Application Ref:	3/2025/0696			 Ribble Valley Borough Council www.ribblevalley.gov.uk
Date Inspected:	3/10/25 & 10/11/25	Site Notice:	3/10/25	
Officer:	BT			
DELEGATED ITEM FILE REPORT:				REFUSAL

Development Description:	Proposed demolition of existing bungalow, to be replaced with the erection of a new dormer bungalow on existing site.
Site Address/Location:	Markhor, Eaves Hall Lane, West Bradford, BB7 3JG.

First Floor Plan

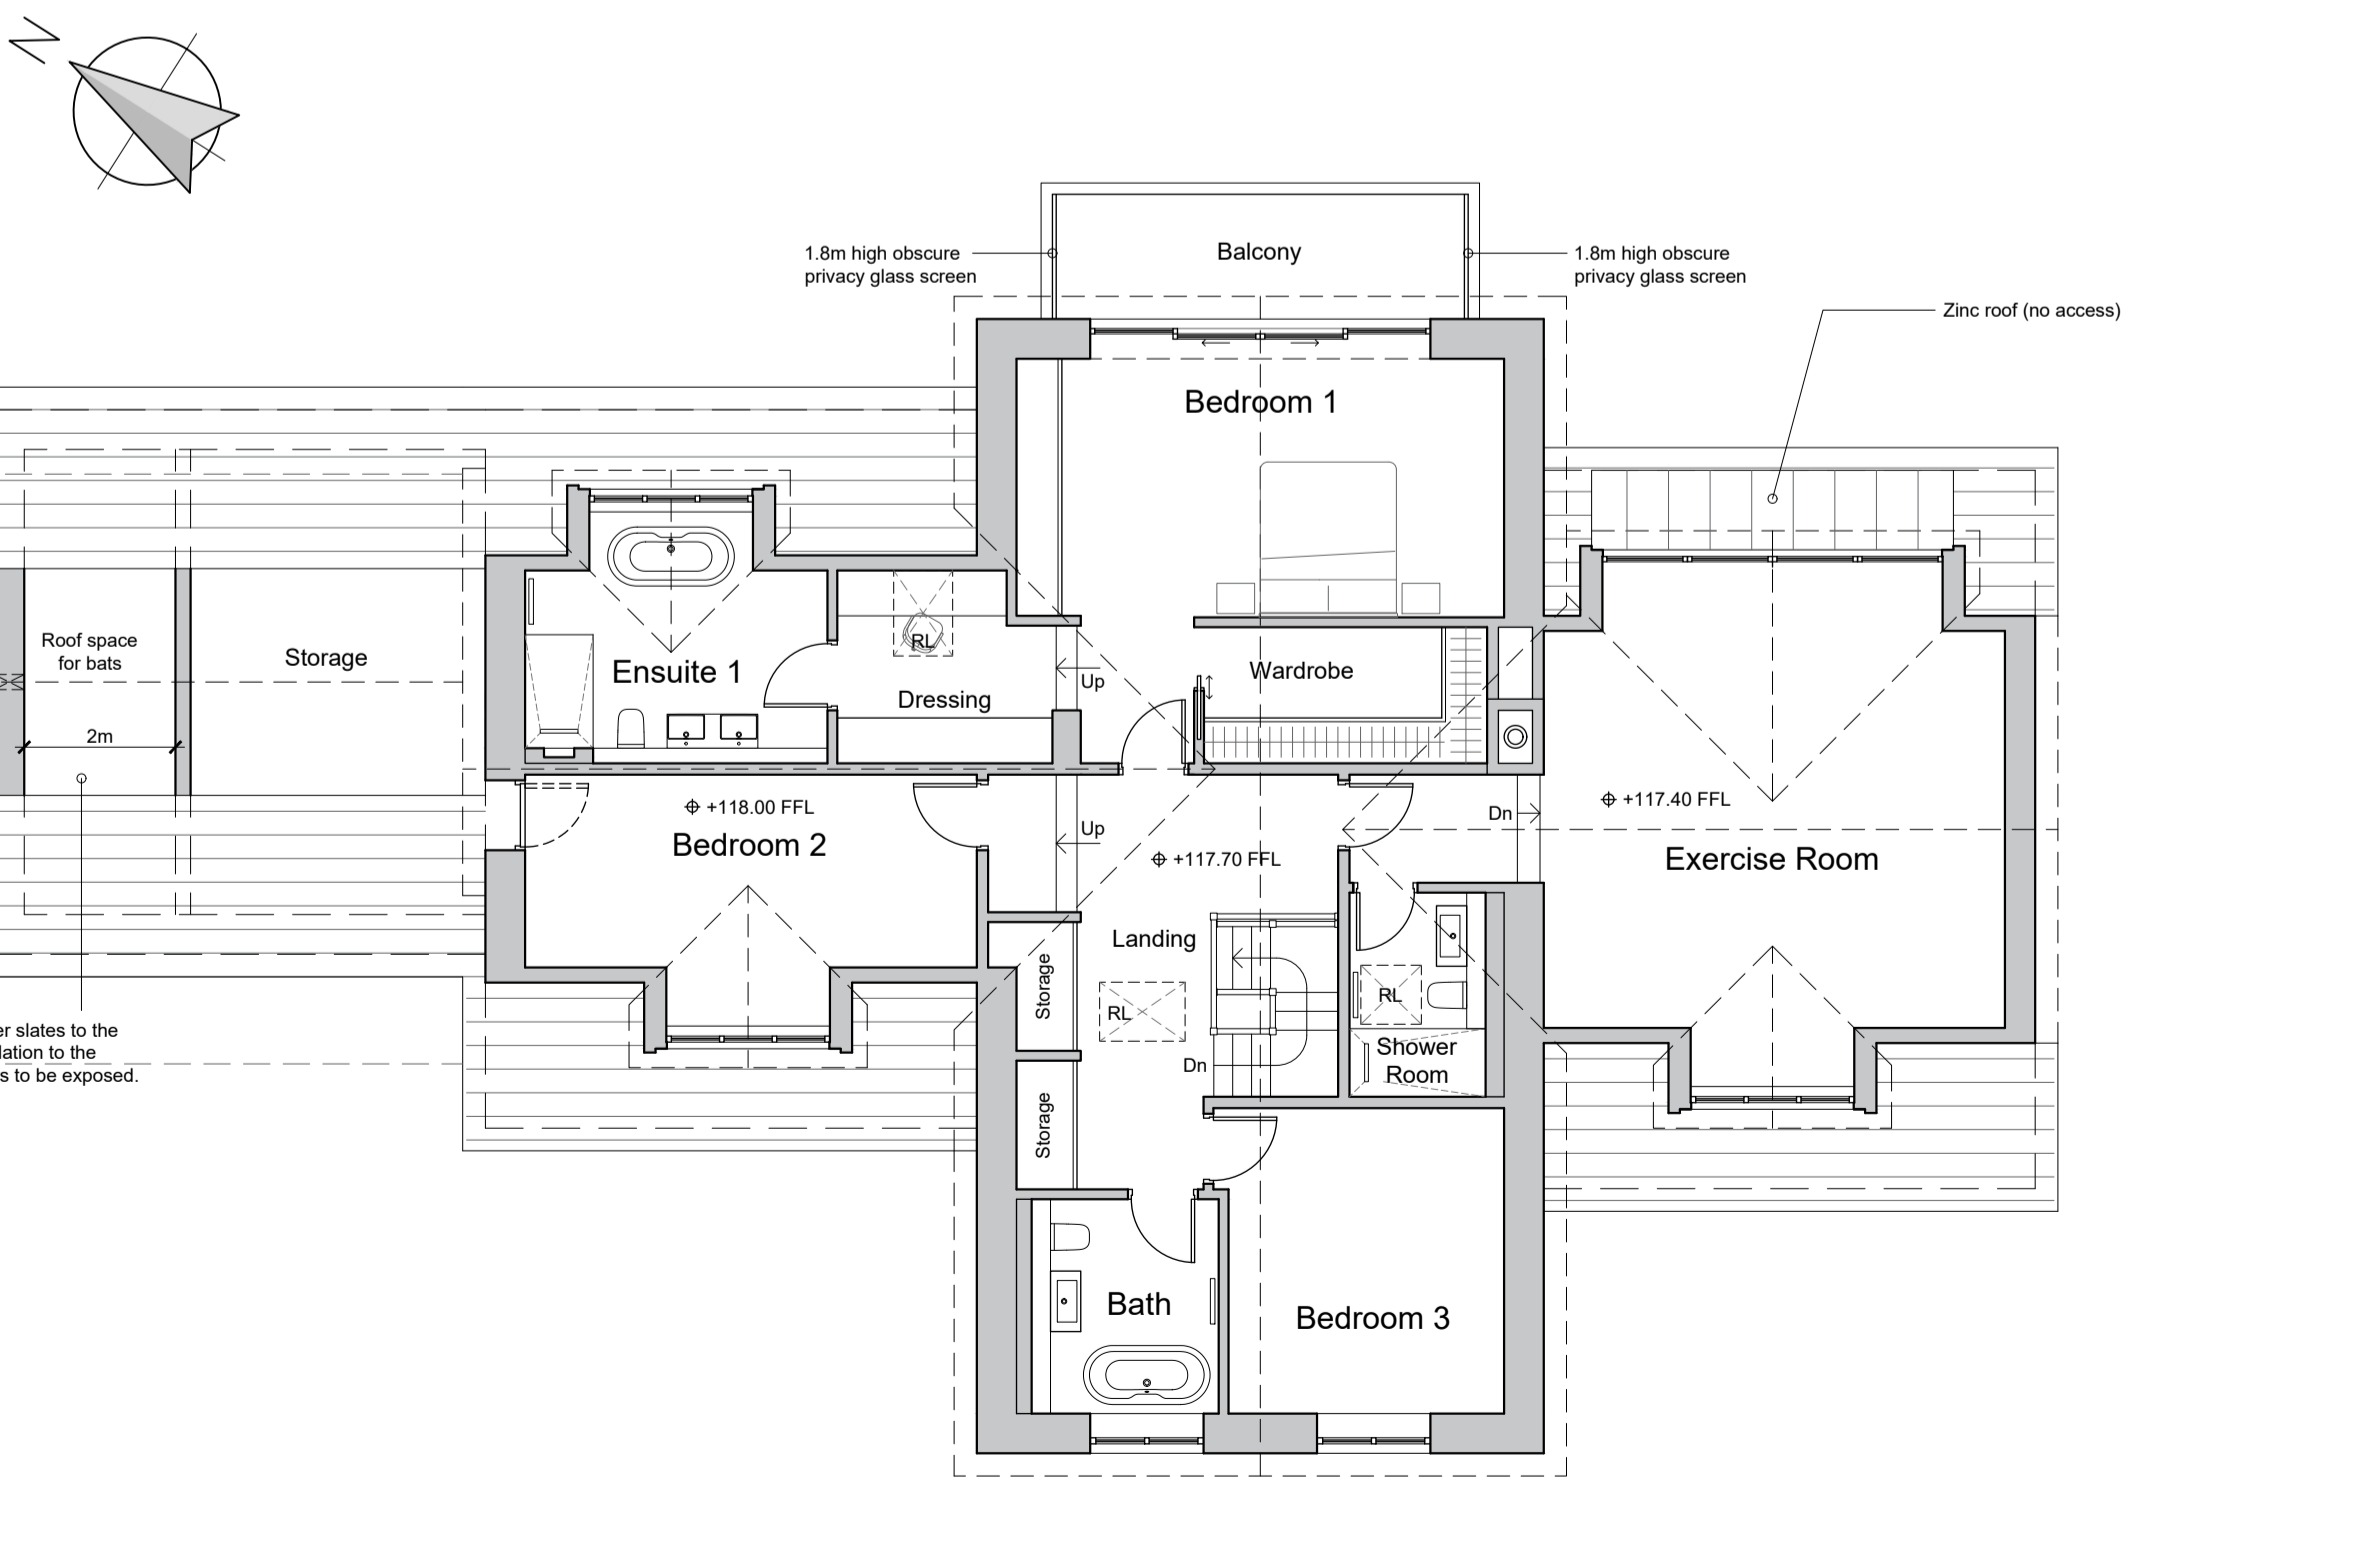
The proposed replacement dwelling would incorporate a projecting balcony on its rear North-eastern elevation however following concerns raised with the applicant with regards to the balcony potentially providing elevated unrestricted sideways views towards the adjacent neighbouring properties a 1.8m high privacy screen comprised of obscure glazing has been incorporated to the side elevations of the balcony which in turn would sufficiently safeguard the privacy of the adjacent neighbouring residents.

Notwithstanding this, the South-eastern elevation of the proposed dwelling would be sited in close proximity (approximately 3 metres away) to the common boundary shared with the adjacent neighbouring property of Highfield, with the rear North-eastern upper level of the proposed dwelling's South-western quadrant accommodating a fully glazed opening that would serve an exercise room. The fully glazed opening serving the exercise room originally accommodated two full height doors and a Juliet balcony and it was conveyed to the applicant that these features, in conjunction with the site's elevated topography above Highfield would likely allow for largely unrestricted sideways views into the rear neighbouring garden of Highfield which in turn could compromise the privacy of the neighbouring occupants (or at the very least create a distinct sense of being overlooked).

In light of the above issues, the applicant was advised to remove the proposed Juliet balcony feature from the dwelling and to relocate a dwelling of reduced width (either by way of removing the dwelling's double garage / storage component or kitchen & dining / exercise room component) to the centre of the

application site, so as to both address the aforementioned concerns with regards to overlooking and also additional concerns raised with respect to design and visual impact (as detailed below in the report's Visual Amenity/External Appearance' section). An amended proposal has since been submitted with the previously proposed Juliet balcony feature and full height doors having now been removed from the exercise room's rear facing fully glazed opening. Notwithstanding this, the originally proposed width and location of the replacement dwelling has been retained in the amended scheme, along with full height glazing to the North-eastern elevation of the exercise room. As such, given the height of the proposed glazed opening and its proximity to the neighbouring boundary, in conjunction with the elevated topography of the application site, the proposed development would allow for elevated and largely unrestricted views into and towards the rear garden area and lounge windows of Highfield respectively, as evidenced by the case officer's recent site visit photographs.

In contrast, the proposed dwelling would be orientated in the opposite manner with its elongated front and rear elevations facing South-west and North-east respectively. Whilst it is noted that the neighbouring property of Peveril is orientated in a similar manner, its orientation is not reflective of the prevailing alignment of dwellings within the existing street scene therefore the orientation of the proposed dwelling would be largely at odds with the existing pattern of development within the street scene on Eaves Hall Lane. Furthermore, the proposed dwelling would comprise a sizeable width of 27

metres which would be significantly wider than the neighbouring property of Peveril to the extent that the proposed dwelling would occupy the large majority of the application plot width. As such, the proposed dwelling would read as a disproportionate and cramped addition to the site relative to the width of the application plot and would therefore be noticeably at odds with the spatial pattern of housing forming the existing streetscene on the North-eastern side of Eaves Hall Lane. The proposal as originally submitted also proposed to incorporate metal cladding to the entirety of the upper face sections of the property's projecting gable features which was considered to be overtly modern in character and not wholly in keeping with the rural character of the area.

In light of the above issues, the applicant was advised to reduce the footprint of the proposed dwelling and re-site a dwelling of reduced width centrally within the application plot, along with a reduction to the extent of metal cladding within the faces of the dwelling's projecting gable features. An amended proposal has since been submitted with the extent of metal cladding reduced as advised however the 27 metre width of the proposed dwelling has been retained, with the only change to the dwelling's footprint being a further (minor change) step back incorporated to the footprint of the dwelling's integral garage component. Furthermore, whilst the height of the replacement dwelling would be similar to height of existing property, the dwelling's sizeable width in conjunction with its overhanging gable roof profiles and projecting front and rear two-storey gable features would collectively exacerbate the overall bulk and massing effect of the proposed development to the extent that the replacement dwelling would read as a disproportionate, over dominant and incongruous addition to the application site and existing street scene.

Taking account of all of the above, it is considered that the proposed replacement dwelling by virtue of its orientation, width, bulk, massing and height would amount to an over dominant, unsympathetic and incongruous form of development that would be at odds with the prevailing character of residential development within the existing street scene on Eaves Hall Lane. Accordingly, it is considered that the proposed development would be harmful to the visual amenities of the area and for this reason it is not considered that the proposal would in this instance conserve or enhance the character of the surrounding National Landscape. The proposal would therefore fail to satisfy the requirements of Paragraphs 135 (C) and 189 of the NPPF and Key Statement EN2 and Policies DMG1 and DMG2 of the Core Strategy.
